Discharge condition 7 (bins) on previous permission 2019/93605 for erection of 1 dwelling

April Court, Roberttown, Liversedge, WF15 7RB

Application Number: 2022/91872

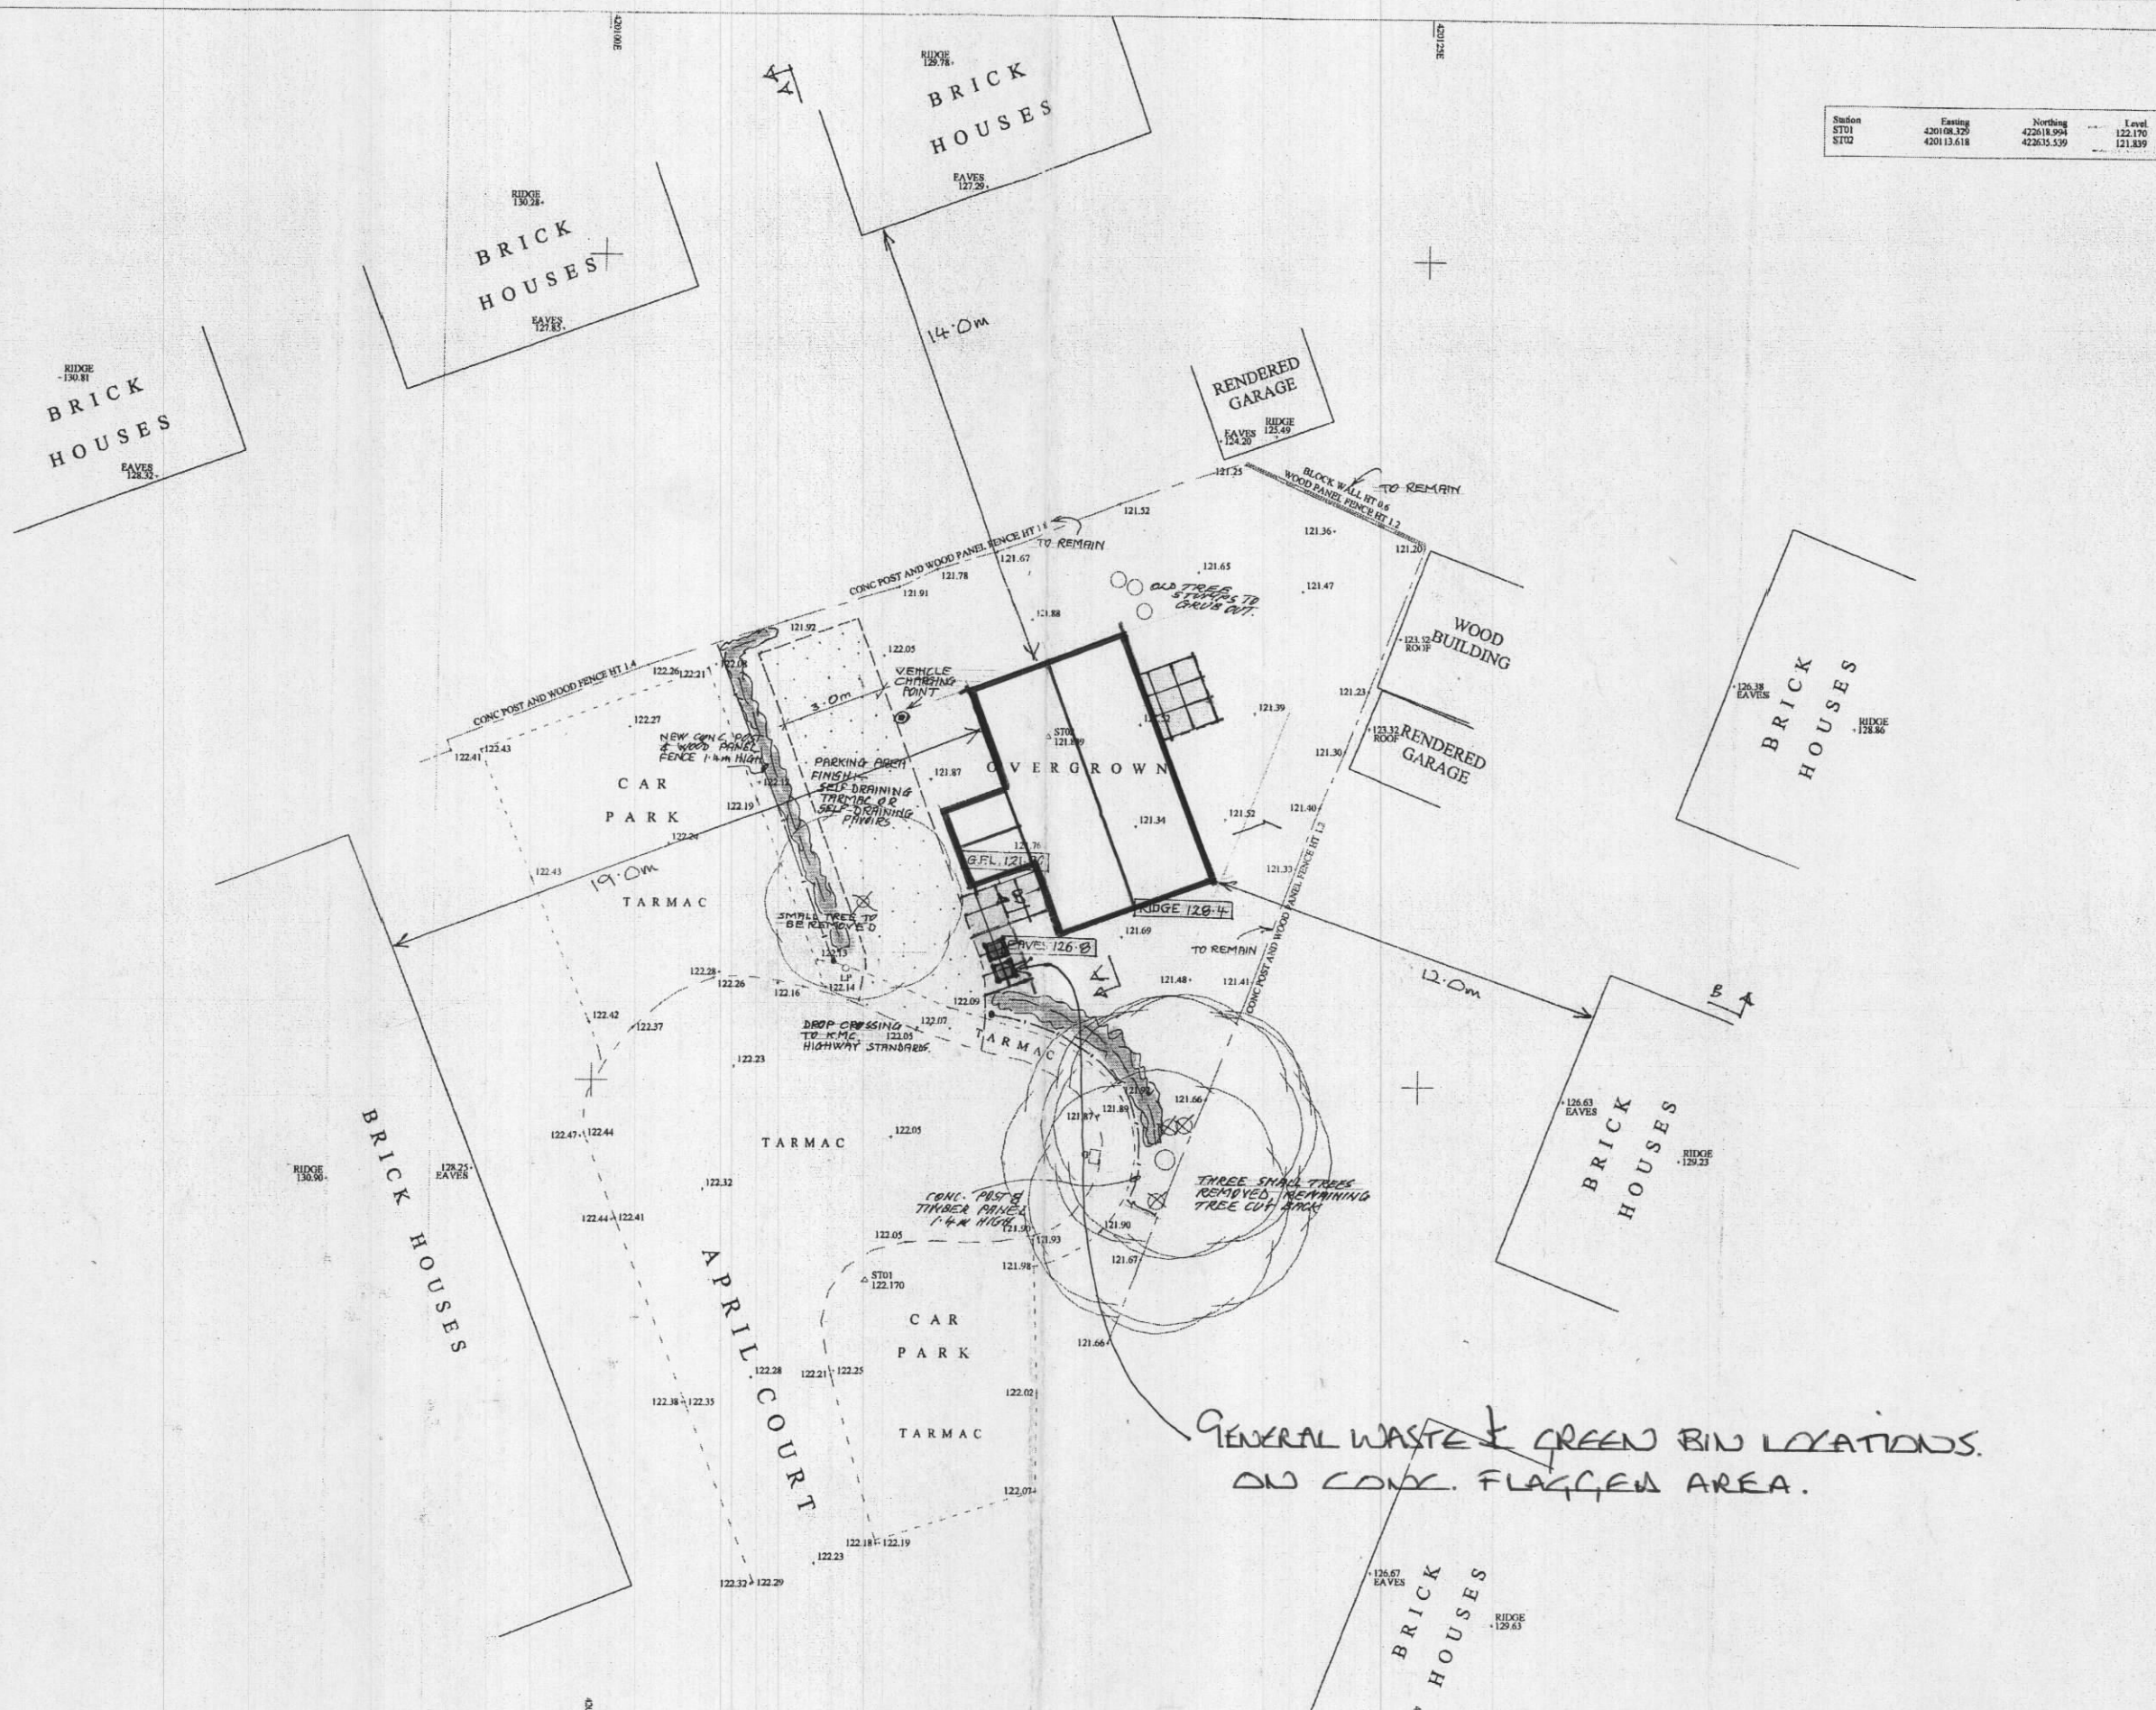
A proposed site plan has been submitted 8057/1 on 6th June 2022. The details are considered acceptable for the purpose of the condition. The condition requires the development to be carried out in complete accordance with the details submitted and maintained for the duration of the development.
